Application No: AL/122/21/T
Site Address: Land east of Arun Veterinary Group Nyton Road Westergate PO20 3YP
Description of works: Fell 1 No. Holm Oak tree.

Thank you for your internet representation made on 11th November 2021 which has been recorded as an objection with the comments as follows:

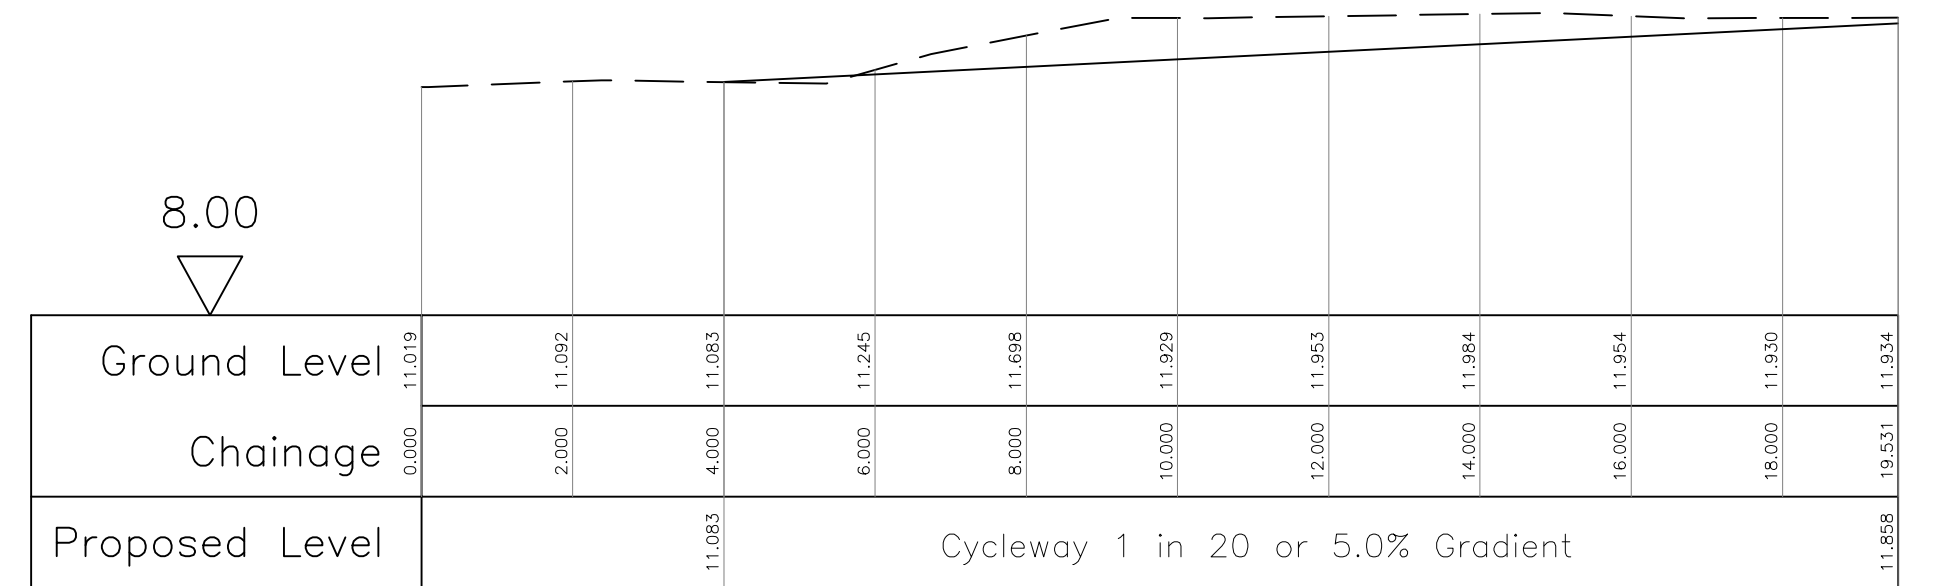
There is no mitigating reason for felling this tree, and suggest that the path is moved slightly as has happened in other similar circumstances and settings. We should be conserving trees as much as possible.
